**SSD 8636: ENGINEERING & TECHNOLOGY PRECINCT DEVELOPMENT
UNIVERSITY OF SYDNEY, DARLINGTON CAMPUS**

**UNIVERSITY OF SYDNEY
RESPONSE TO SYDNEY WATER SUBMISSION**

RE: The University of Sydney – Engineering & Technology Precinct (ETP) – ECI Peer review
Sydney Water Assets

THE UNIVERSITY OF SYDNEY ENGINEERING AND TECHNOLOGY PRECINCT (ETP) - STAGE 1	Drawing Title SITEWORKS AND STORMWATER DRAINAGE PLAN - SHEET 1
--	---

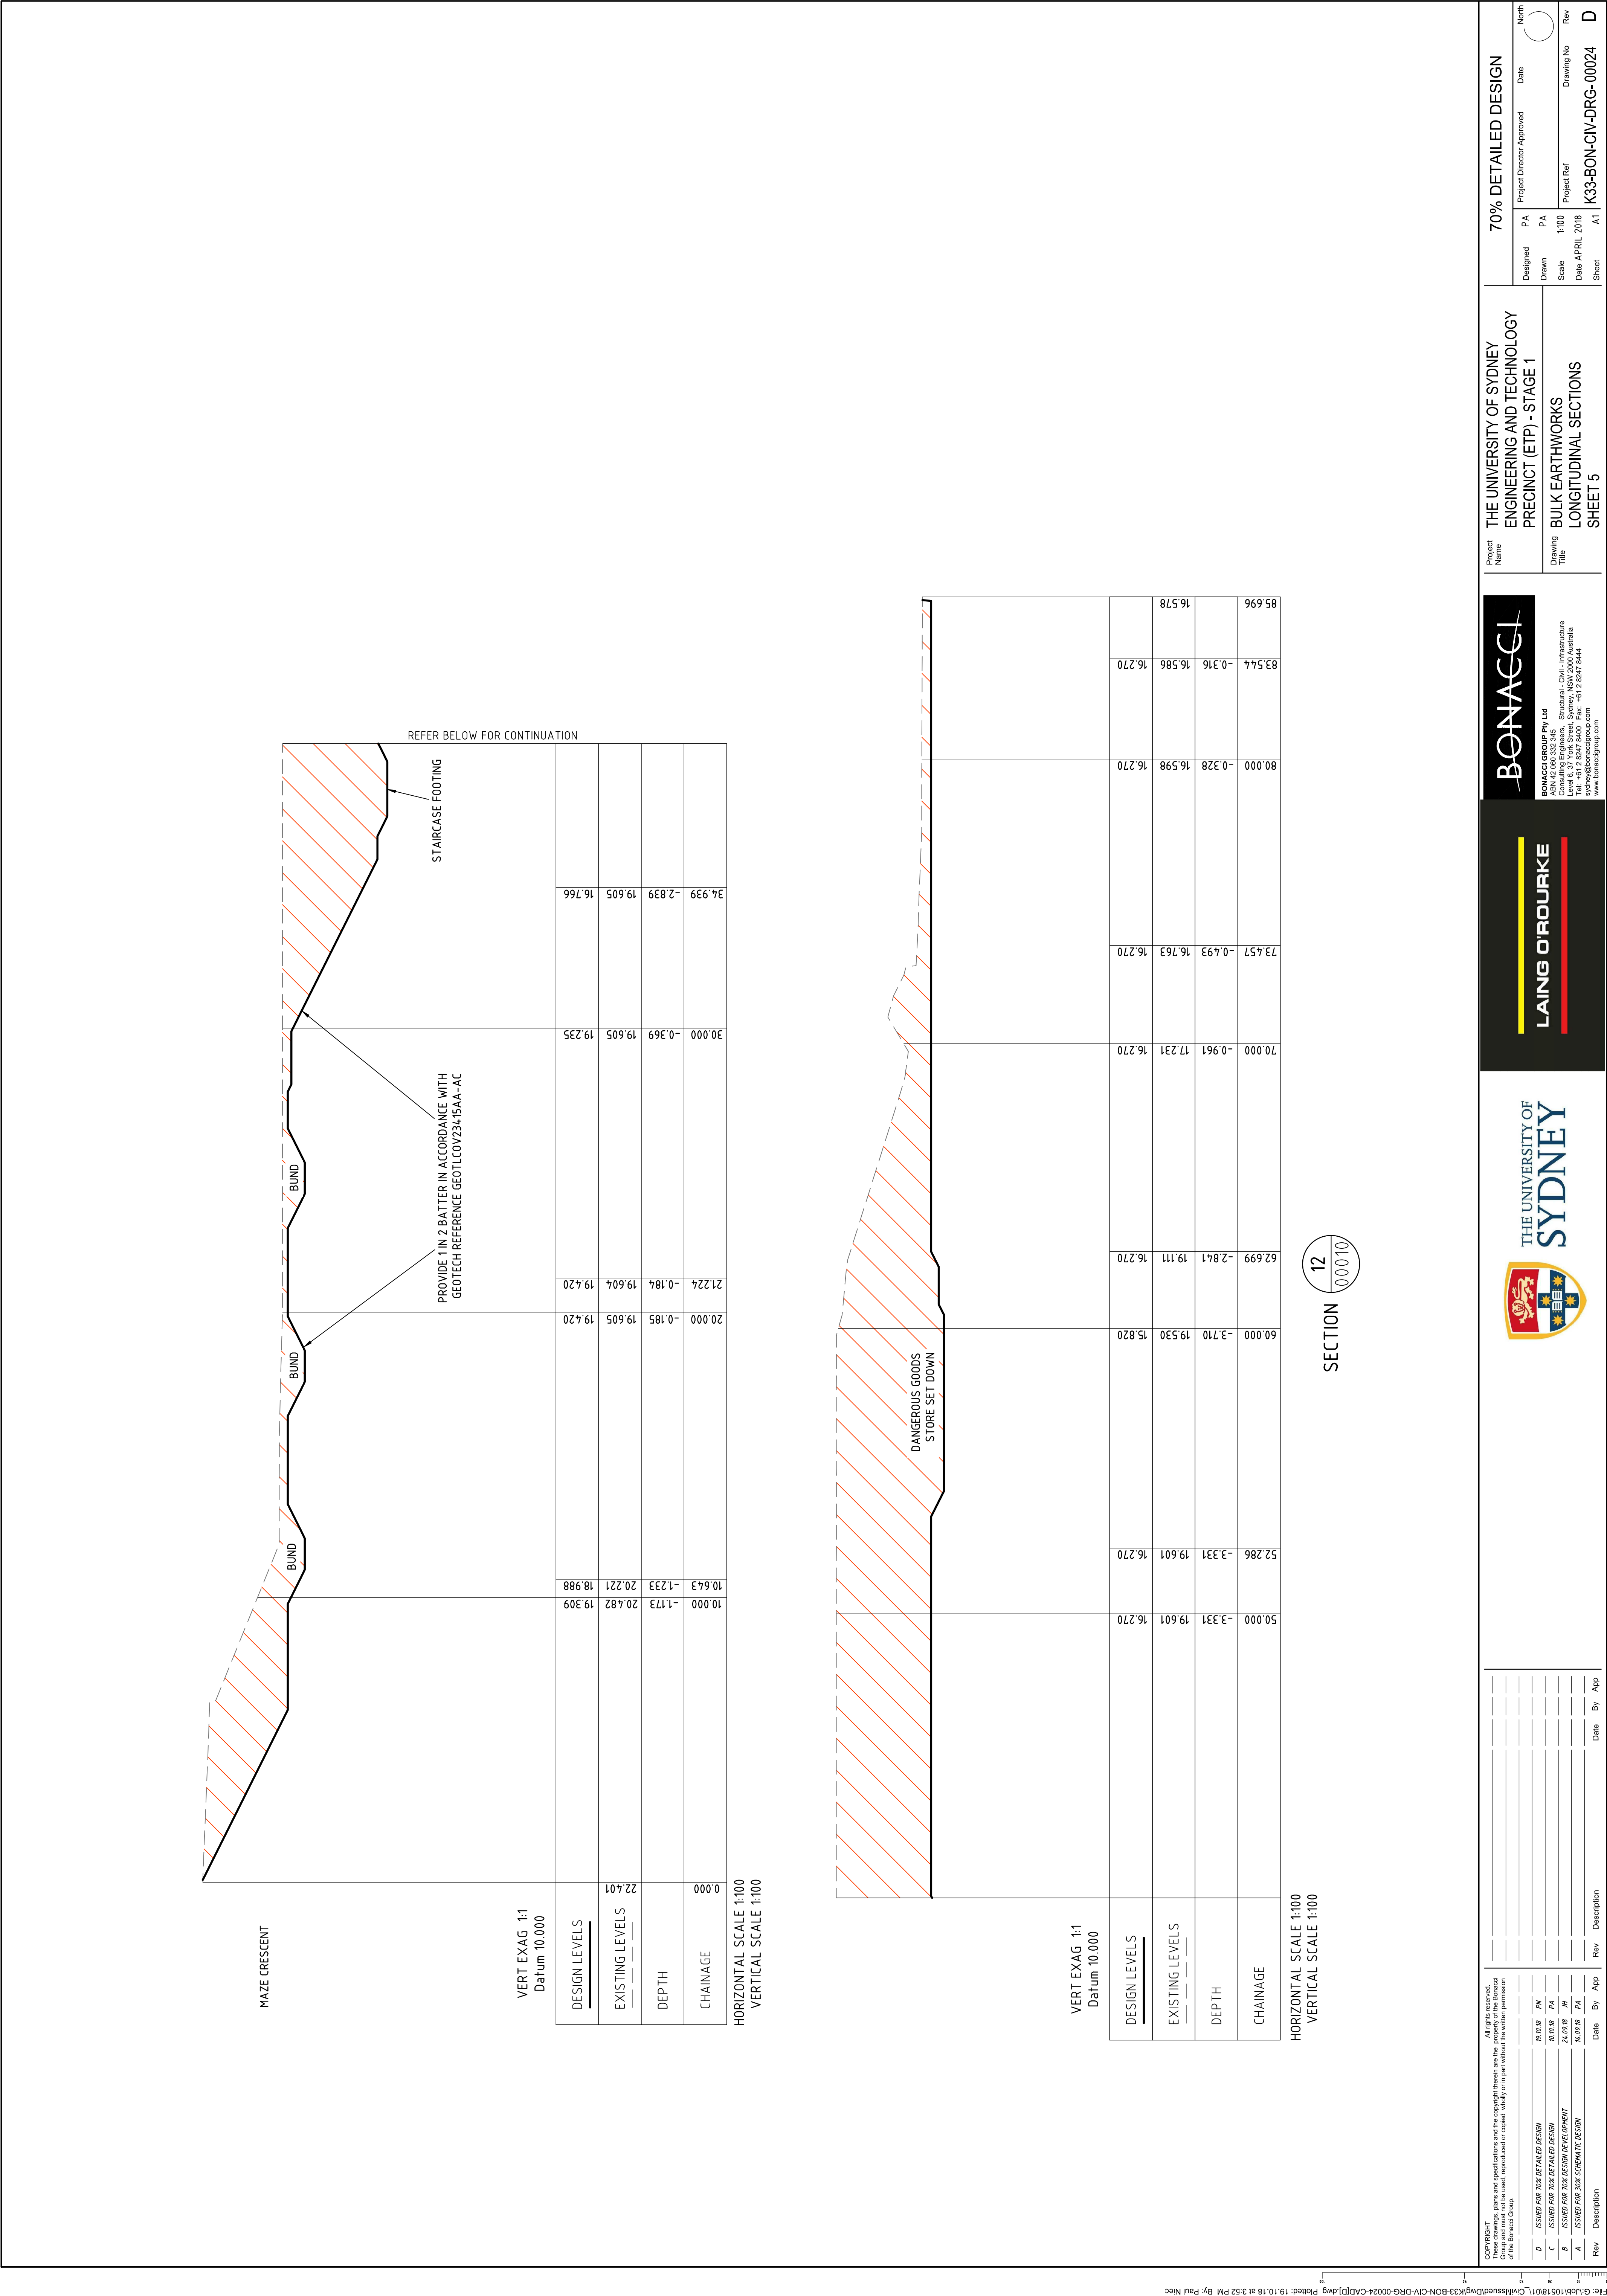
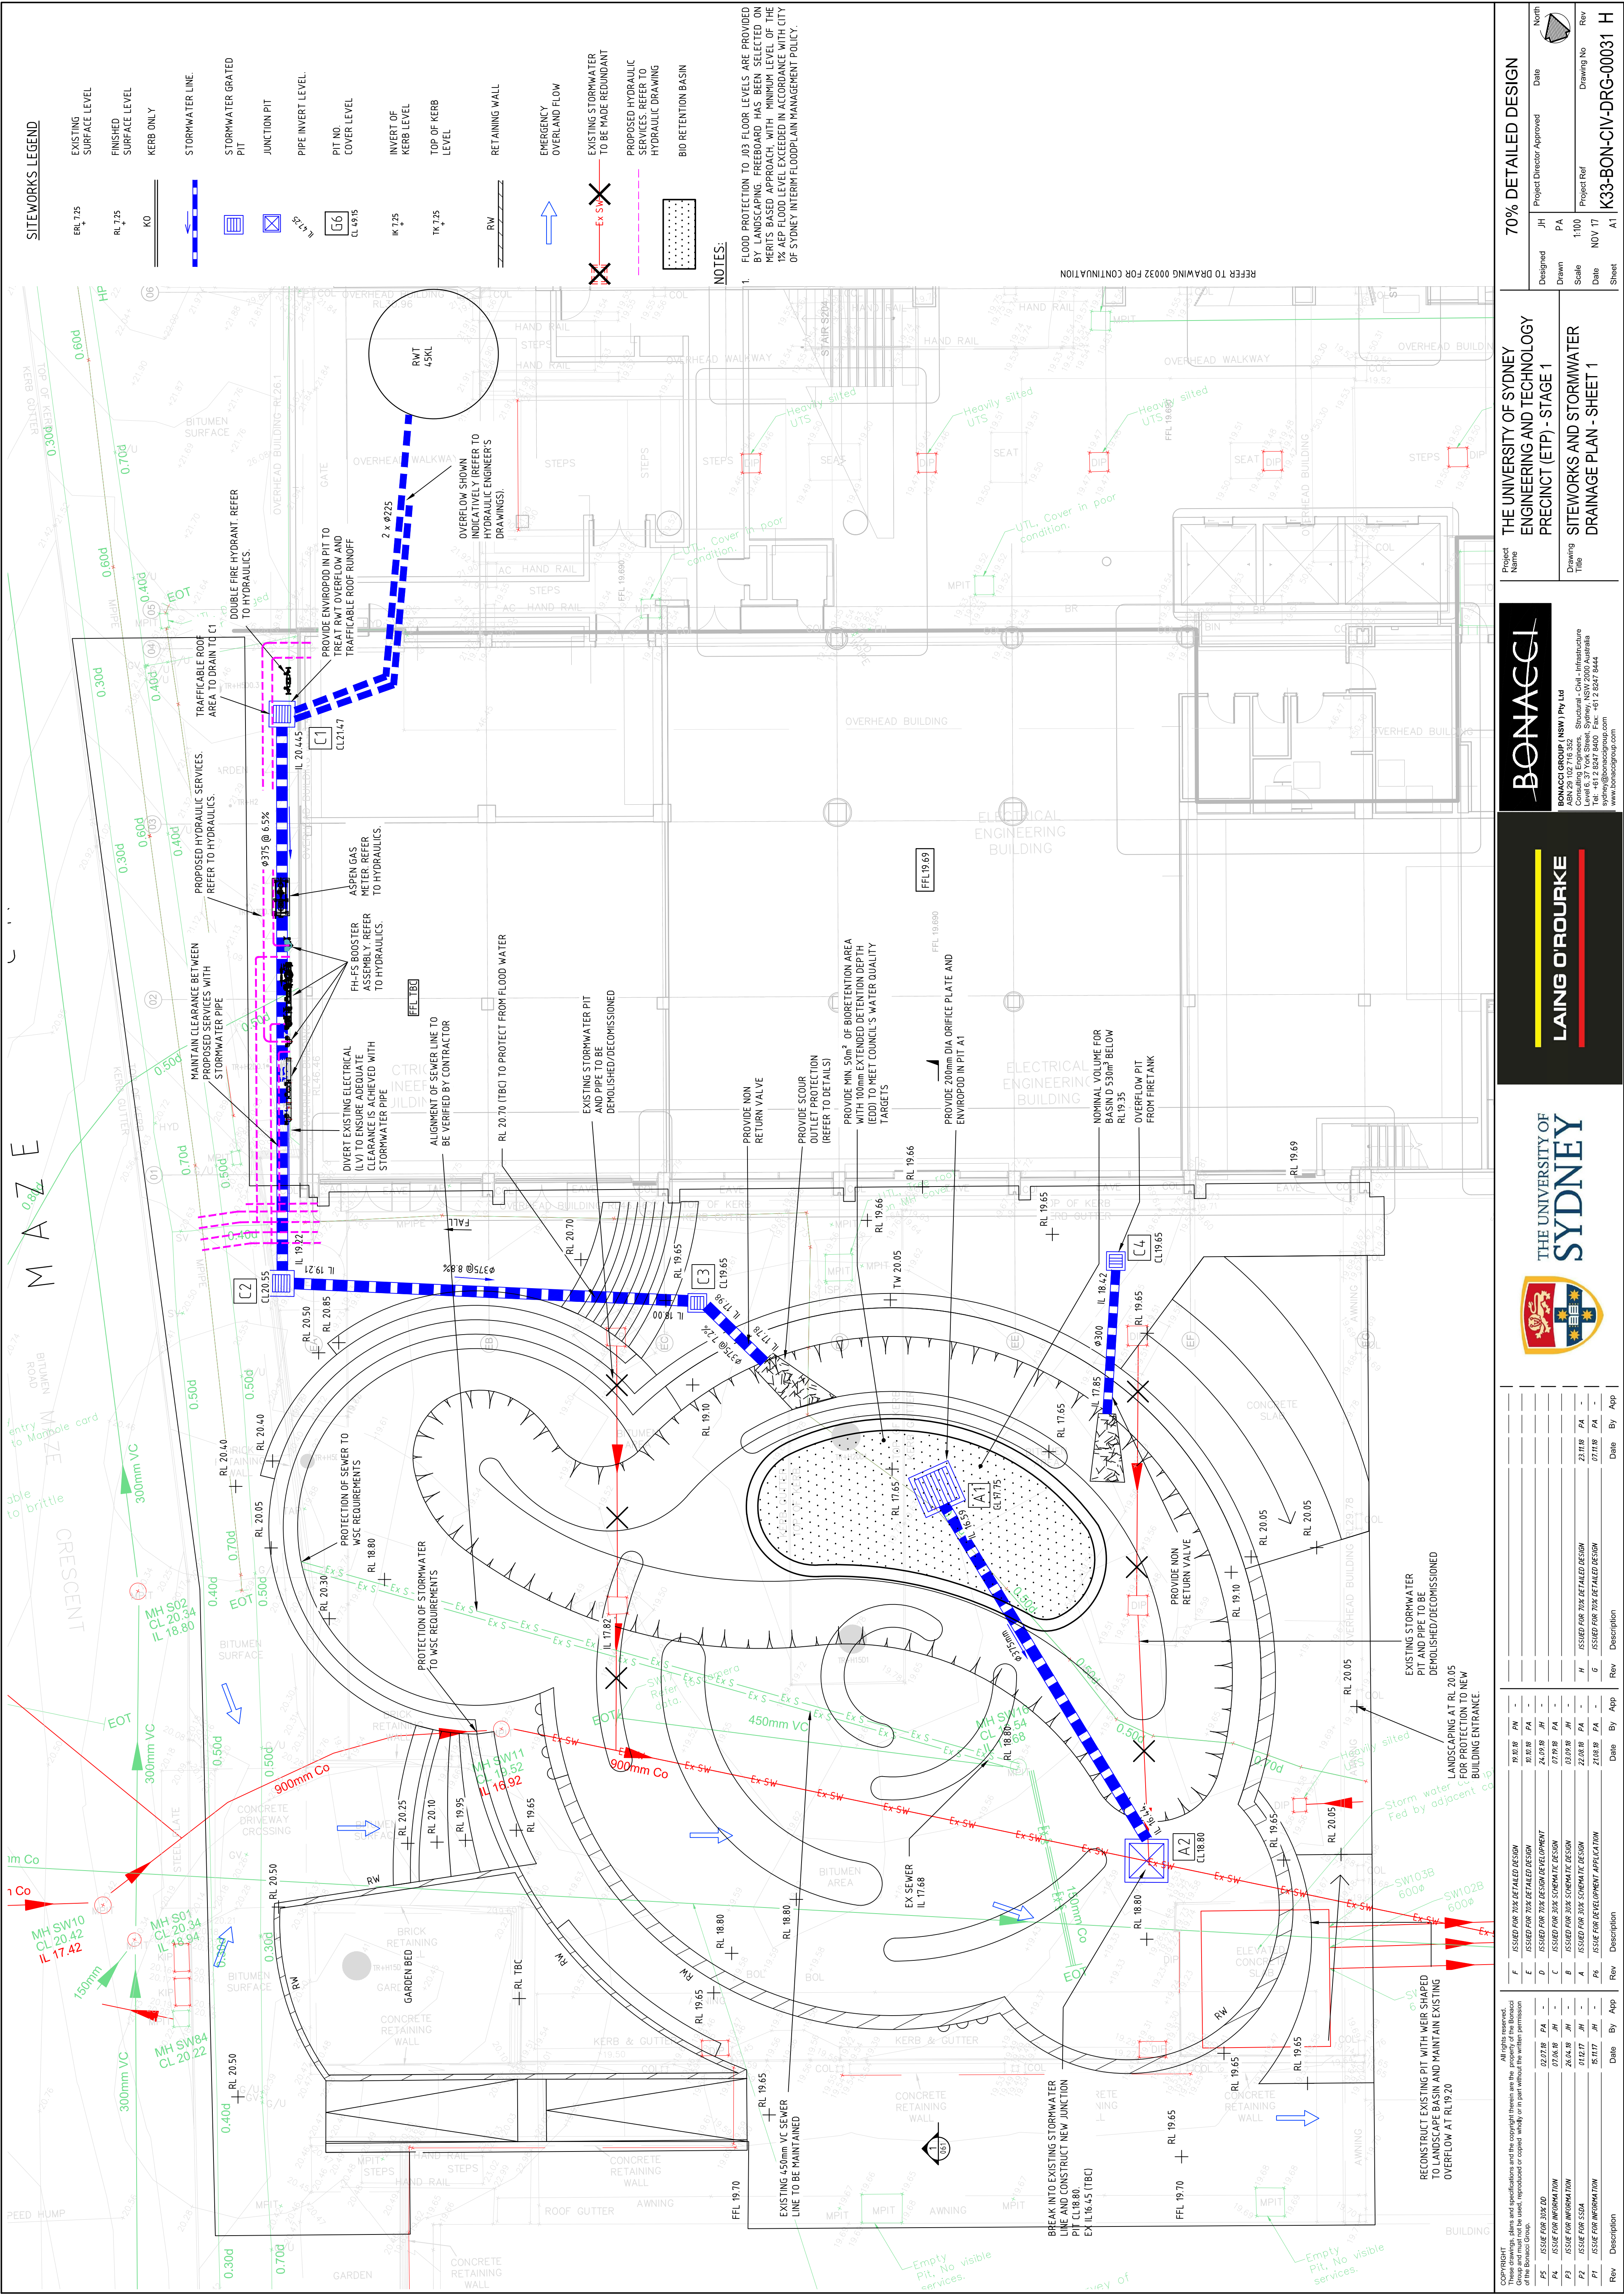
SSD 8636 – ENGINEERING & TECHNOLOGY PRECINCT DEVELOPMENT	
RMS ISSUE	UNIVERSITY OF SYDNEY PROJECT RESPONSE
<p>Sydney Water object to the proposal as it does not meet Sydney Water's building over and adjacent to the stormwater assets requirements.</p> <p>The applicant is required to submit the elevation drawings with the stormwater channel, to ensure that the proposed buildings and permanent structures are 1m away from the outside face of the stormwater channel.</p>	<p>The University attaches a letter by Warren Smith & Partners, dated 27 September 2018, and corresponding plans. The WSP letter concludes the following:</p> <p>“There are no building structures proposed about the stormwater asset except for the small walls and pit outlined above. These works will need to go through the appropriate Sydney Water new connection and building plan approval process to ensure that there are no impacts to existing SWC assets in compliance with Sydney Water code.</p> <p>Warren Smith & Partners has been a Sydney Water Servicing Coordinator for over twenty years and it is our opinion that there will be no non-conformances with Sydney Water guidelines provided appropriate engineering solutions are adopted.”</p> <p>Attachments:</p> <ul style="list-style-type: none">• Letter from Warren Smith & Partners, dated 27 September 2018• Hydra Plan showing DN900 pipe• Site Works and Stormwater Drainage Plan, prepared by Bonacci

We have reviewed the letter received from Sydney Water dated 24th May 2018, which states that the proposed development does not comply with Sydney Water's guidelines for building over and adjacent to stormwater assets. The works proposed to be undertaken are summarised as follows:-

- Creation of a landscaped garden where an existing car park currently sits;
- Reduction of the ground levels by approximately 800mm;
- Provision of low height landscaped retaining walls around the garden and above stormwater asset;
- Provision of a new stormwater pit on the DN900 asset with a new connection.

There are no building structures proposed about the stormwater asset except for the small walls and pit outlined above. These works will need to go through the appropriate Sydney Water new connection and building plan approval process to ensure that there are no impacts to existing SWC assets in compliance with Sydney Water code.

Warren Smith & Partners has been a Sydney Water Servicing Coordinator for over twenty years and it is our opinion that there will be no non-conformances with Sydney Water guidelines provided appropriate engineering solutions are adopted.
